Iglu Redfern II
80-88 Regent Street Redfern

BCA Assessment Report
Report 2018/0859 R1.1

Prepared for Iglu Pty Ltd
August 2018

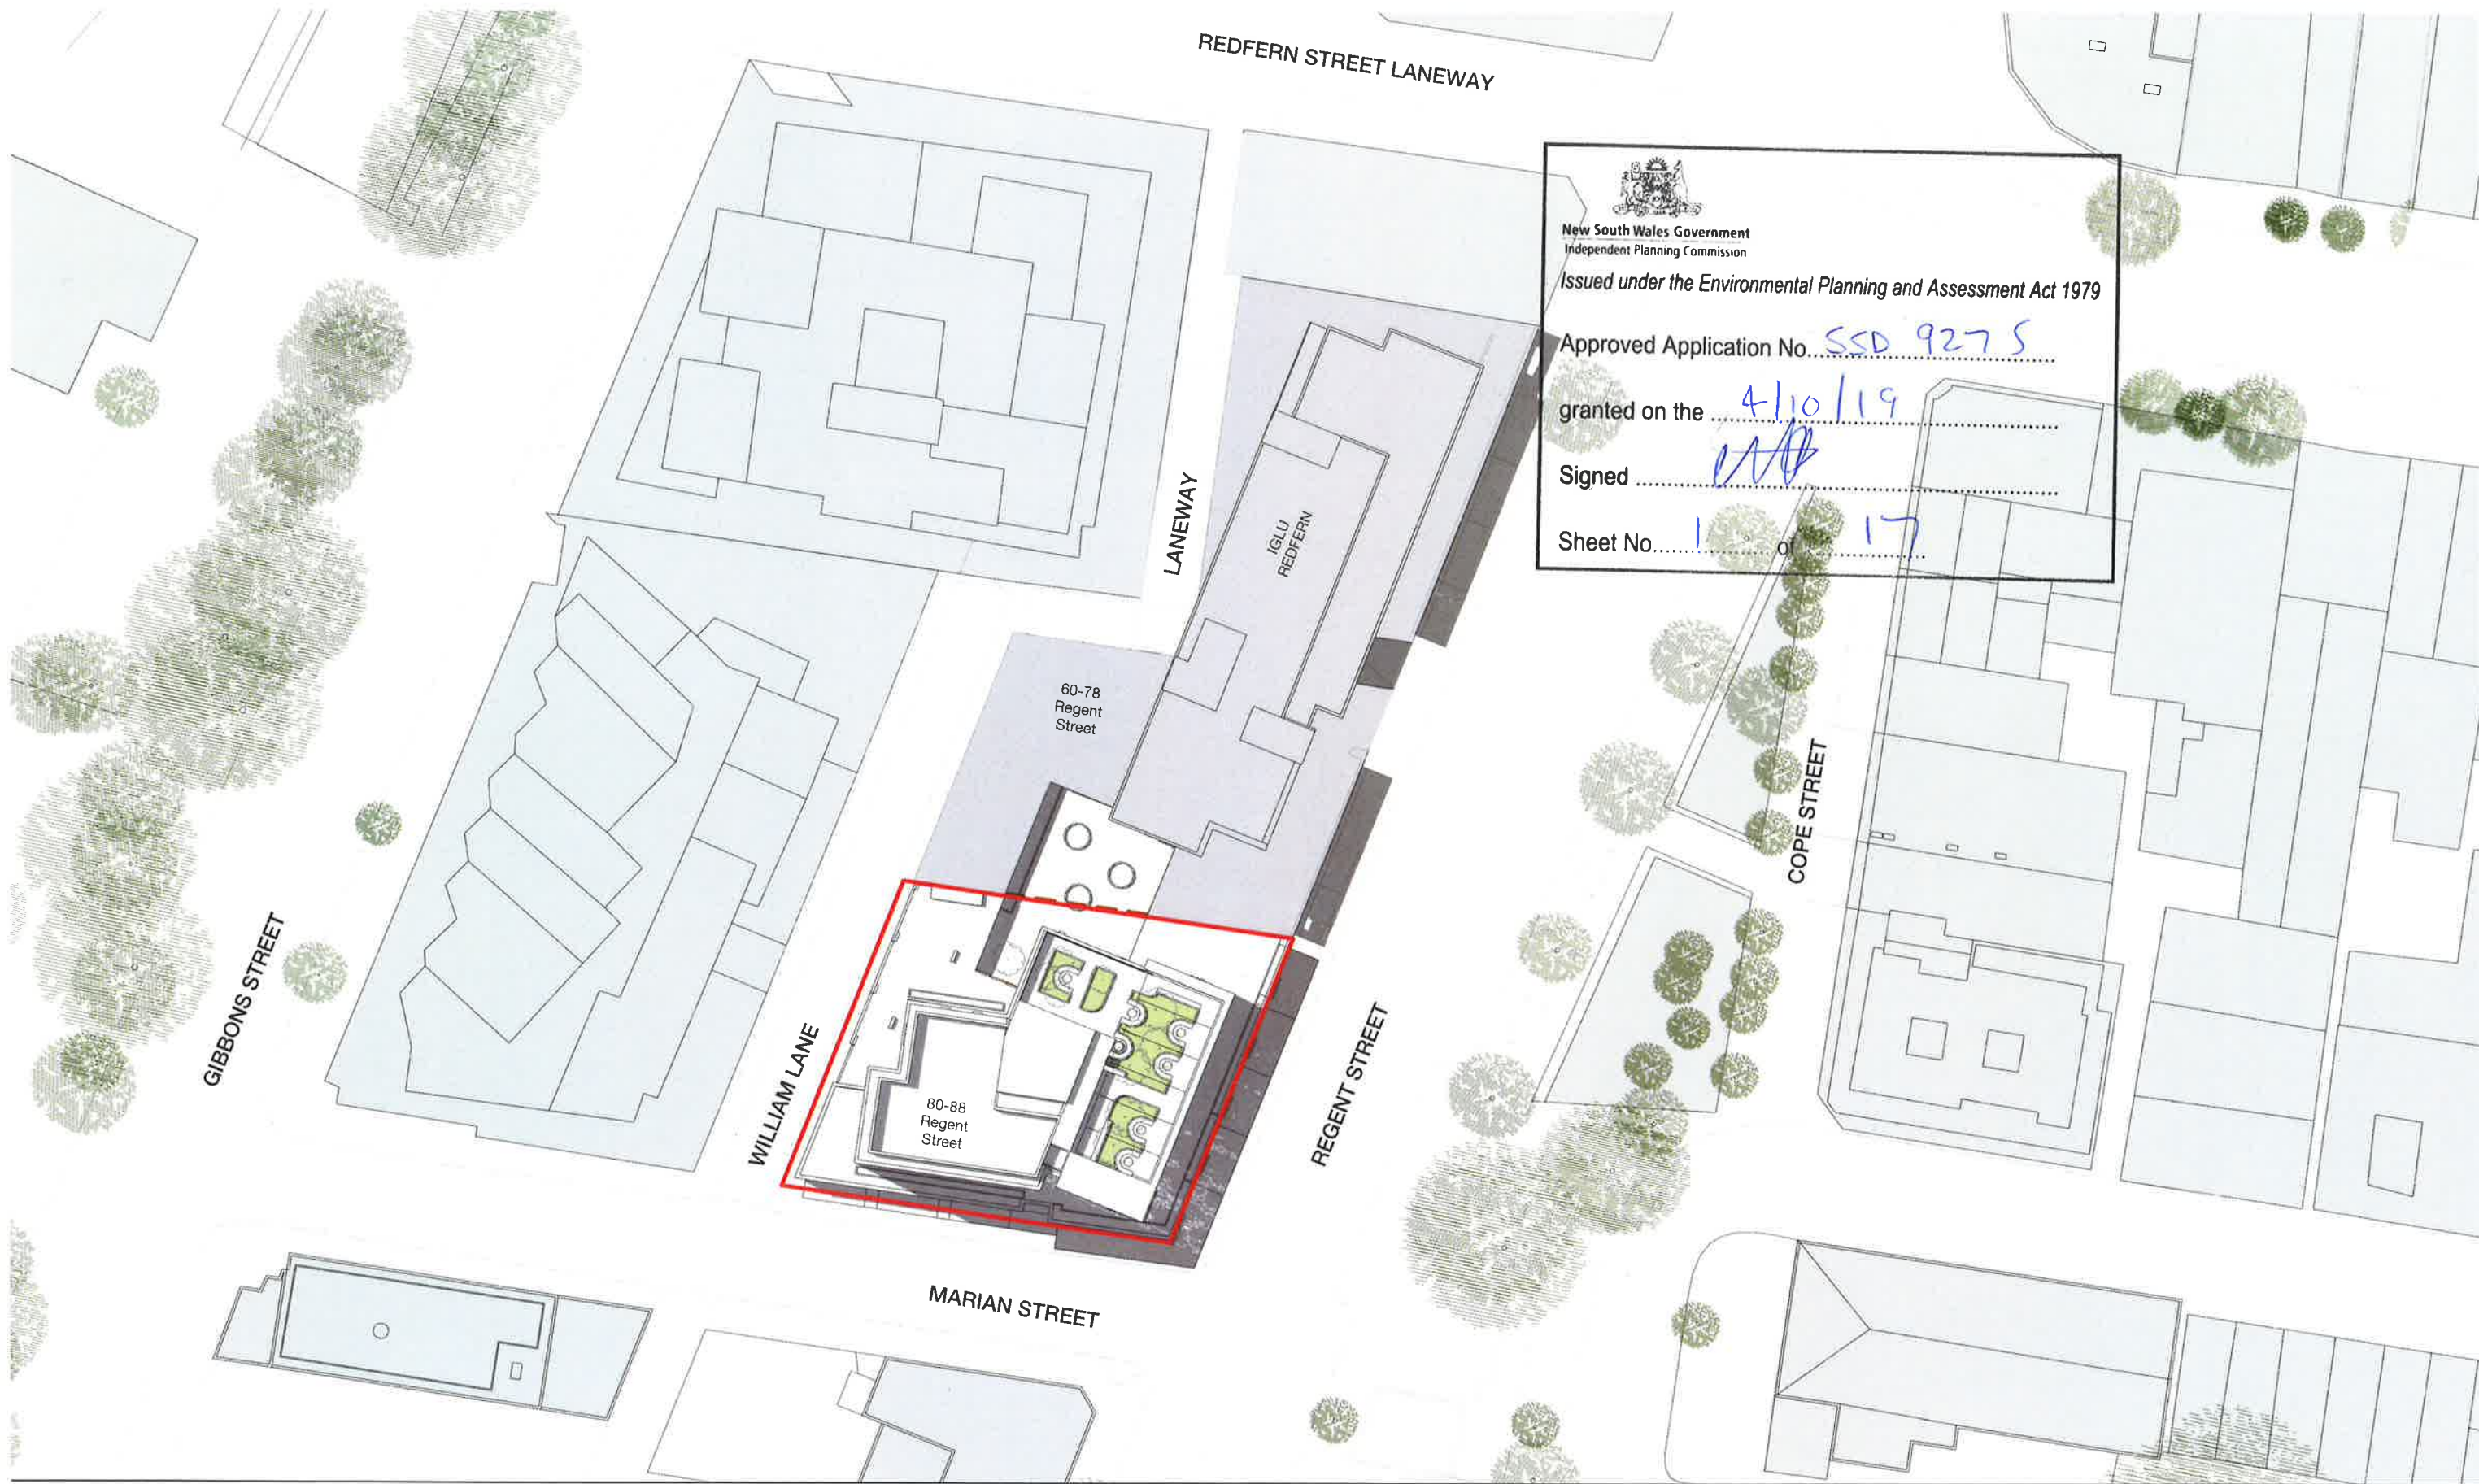
1. Swing of the fire stair doorway of ground floor impeding across the required path of travel of the back of house corridor on ground floor.

Item	DTS Clause	Description of Non-compliance	Requirement to Satisfy BCA
1.	D2.20	The fire stair door swing on ground floor impedes more than 100mm into the 1m path of corridor exit when the door is fully open.	Amend design to ensure door swing is not located across the corridor.
